## Application for Removal or Variation of a Condition following Grant of Planning Permission or Listed Building Consent

Construction of a single-storey side extension and two-storey rear extension

61421/APP/2024/2854

Condition 2

ADDRESS		
4 Almond Avenue Ickenham UB10 8NA		
DRAWING TITLE		
Plans proposed		
PROPOSAL		
Planning permission 61421/APP/20242854 condition amendment		
SCALE	DATE	REV
1:100	Apr 26	
DRAWING NUMBER		
L.01

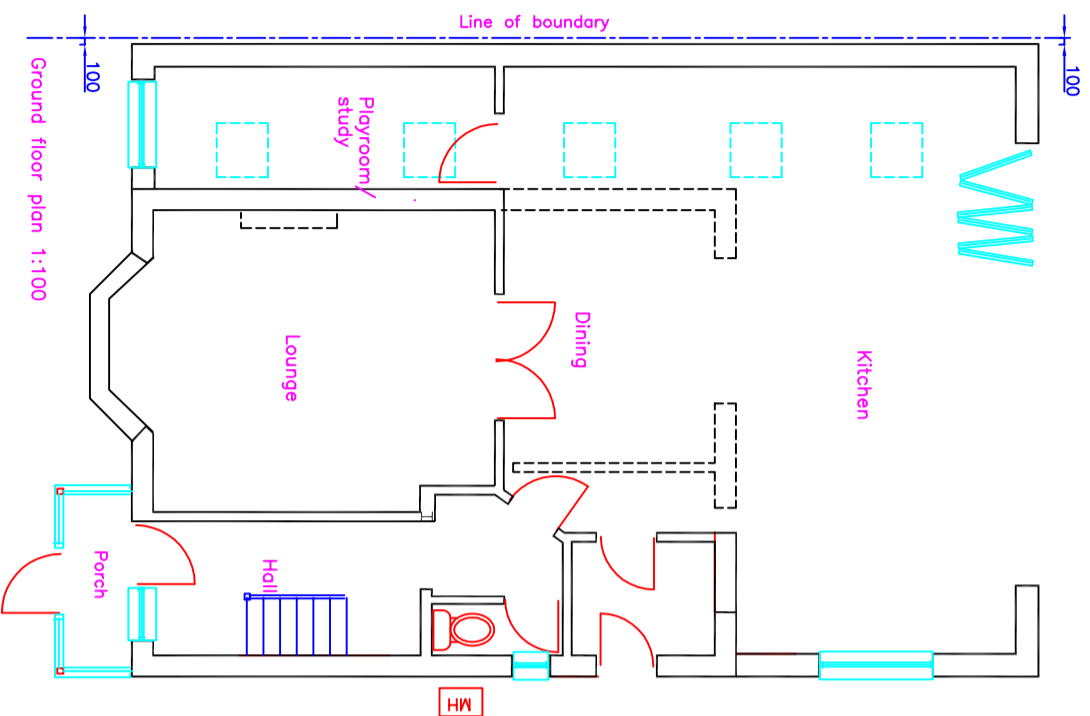
The variation relates to a slight reduction in the separation distance between the side elevation of the extension and the boundary. This change is minimal in scale and does not result in any material impact on neighbouring amenity, including loss of light, outlook, or sense of enclosure.

The condition is proposed to be varied to allow the side extension to be retained as constructed, with a separation distance of approximately 100mm between the outer face of the extension wall and the boundary, in place of the 250mm shown on the approved plans.
